6 November 2013

Name: Garth Lumb
Address:
394 Wilson St
Darlington 2008

**Modification Request for the University of Sydney Abercrombie Precinct
Redevelopment: Application Number: MP07_0158 MOD 3**

Title
Scale
Date
Number
0 2 4
10 20m
Ground Floor Plan
MARK UP SET
1:200@A1
11.10.13
4001_DA02-D
© copyright nettleton tribe partnership pty ltd

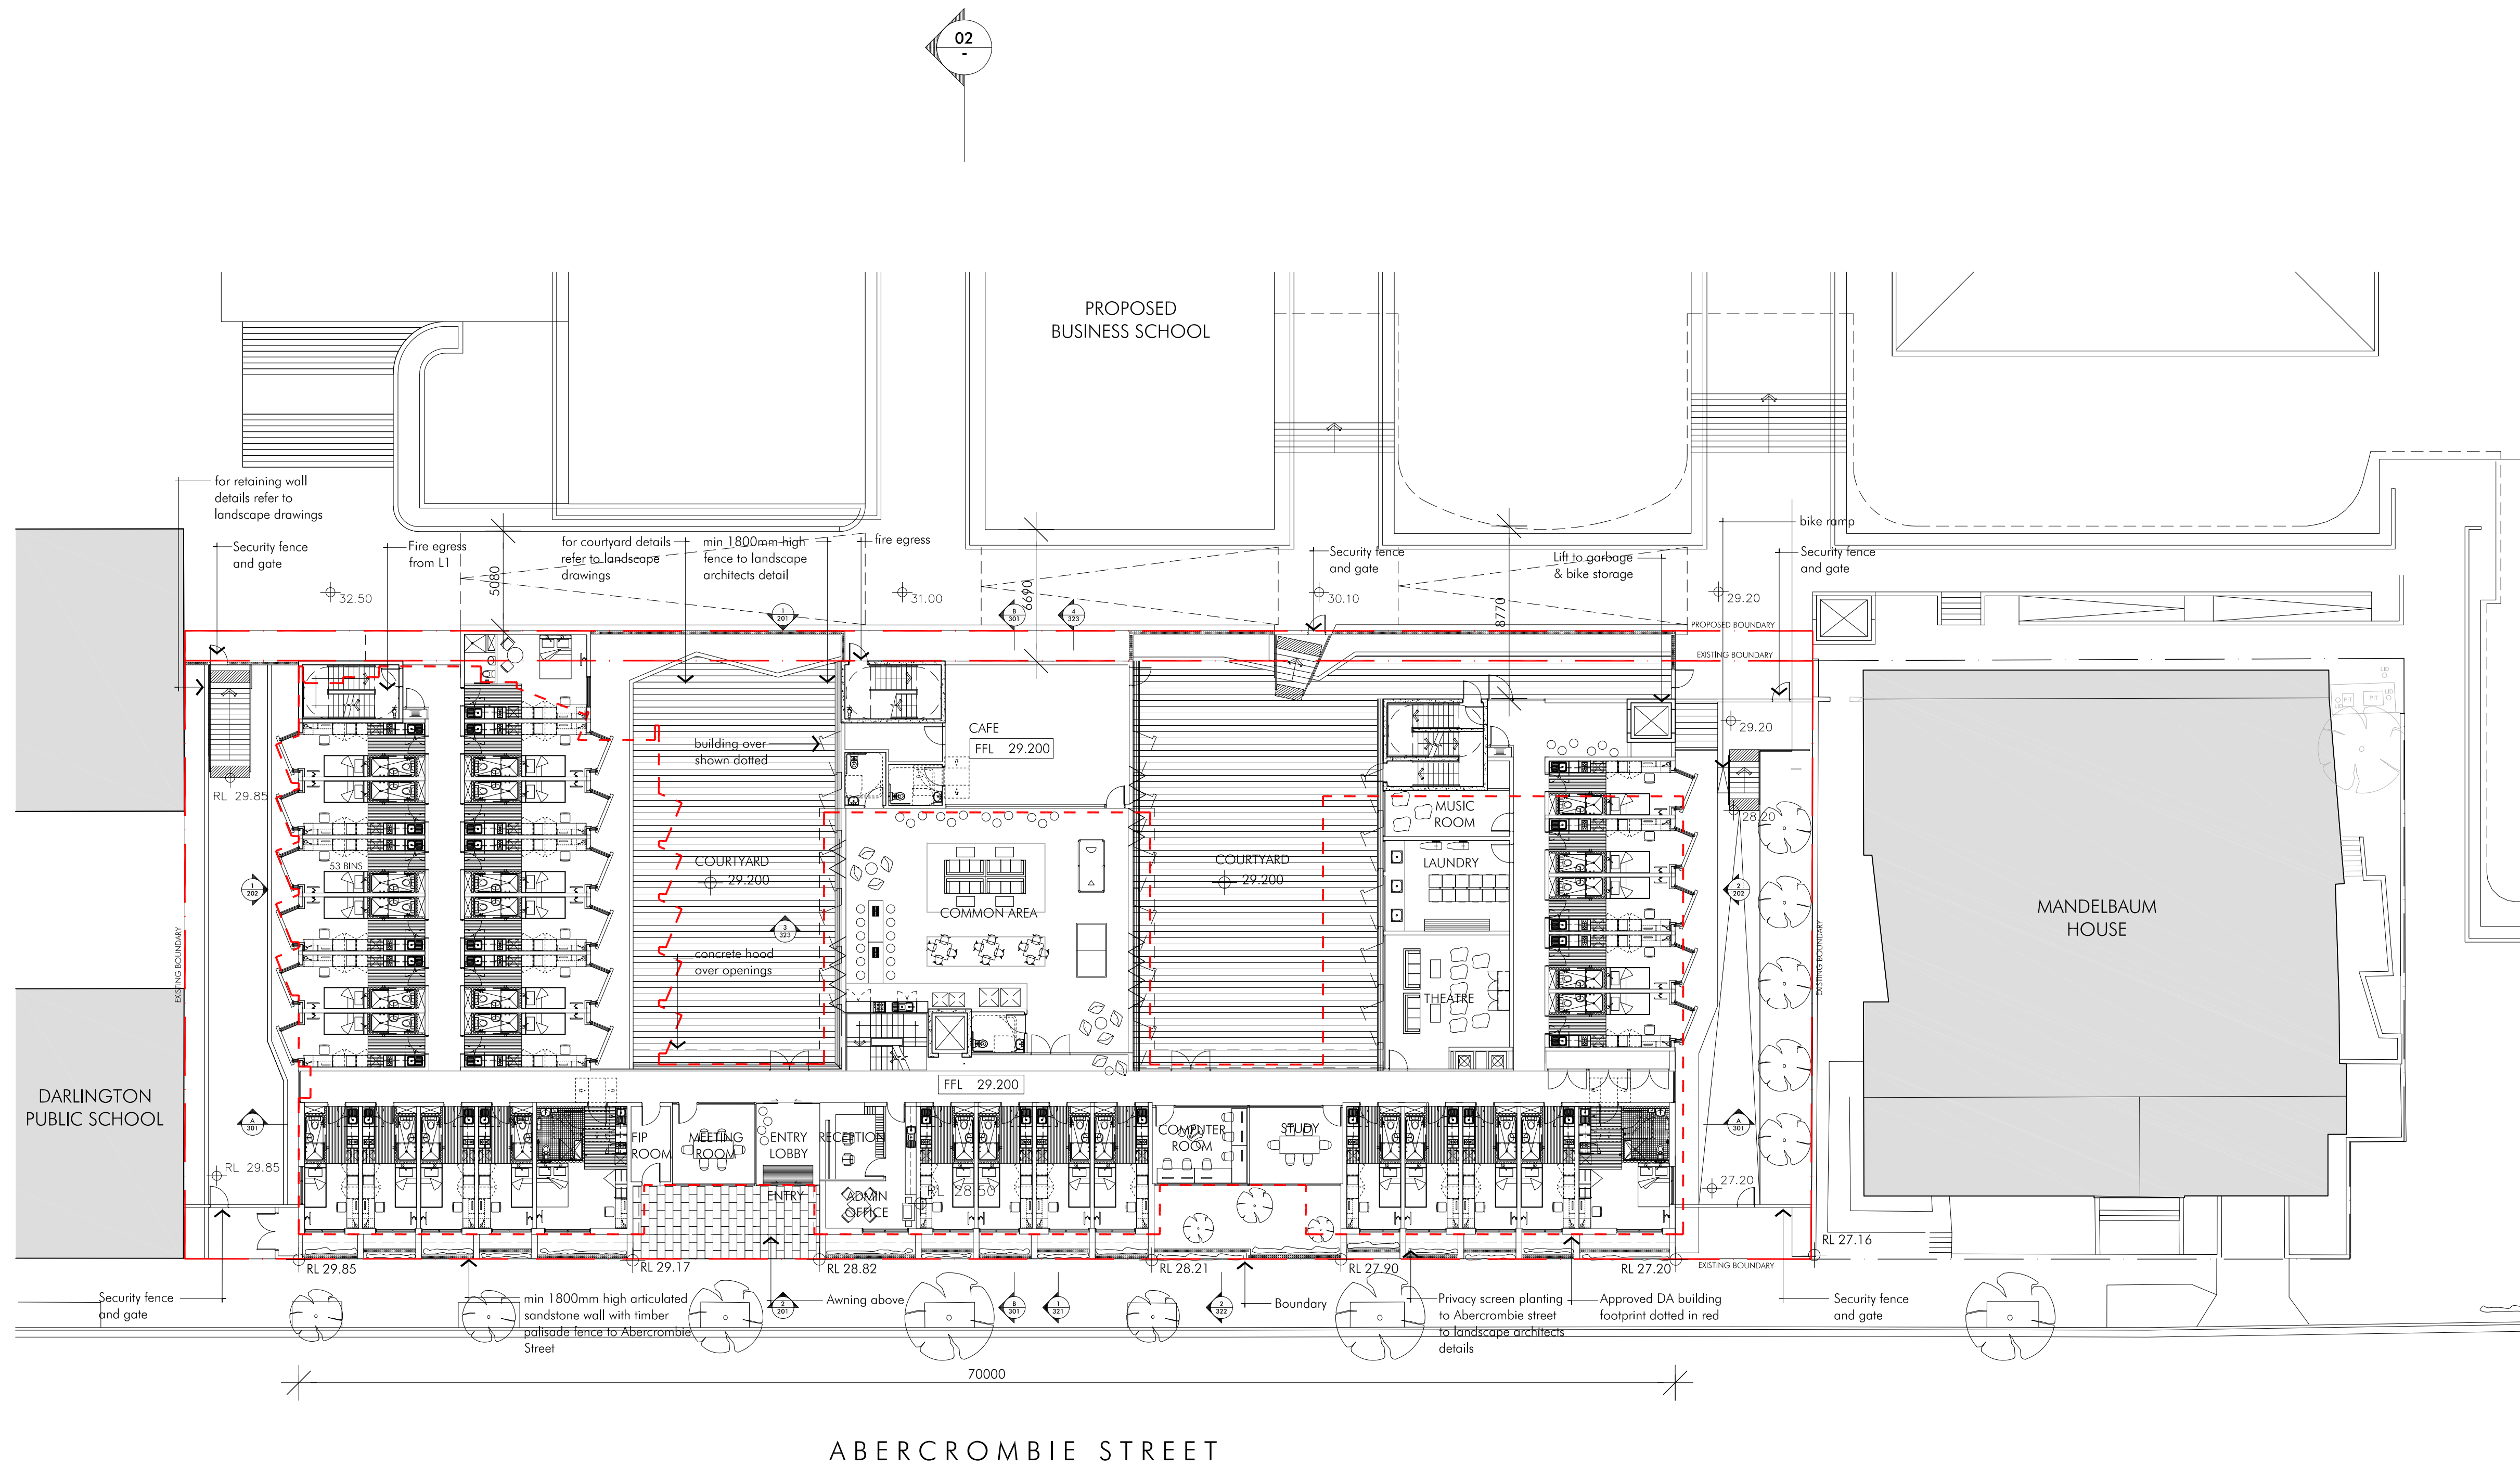
- The front of the Student Accommodation building should be built 2 metres back from the Abercrombie Street boundary. It should be set back from this boundary so that it is in line with Mandelbaum House as it was originally planned and presented to the community. The footprint of the buildings currently on the site, The Shepherd Centre and Boundary Lane Children's Centre, were built approximately 2 metres back from the Abercrombie Street boundary and align with Mandelbaum house. Therefore, the front footprint of the proposed Student Accommodation building should be the same as those buildings occupying the site at present and not be built up to the Abercrombie street boundary.

- The facade of the proposed Student Accommodation building does not reflect the heritage appearance of the Victorian terraces on Abercrombie Street as Mandelbaum House does. Therefore, it should be set back to allow for extensive vegetation and trees to be planted in front of the building on Abercrombie Street to help preserve the heritage streetscape and improve both the aesthetics and the environment of the street.
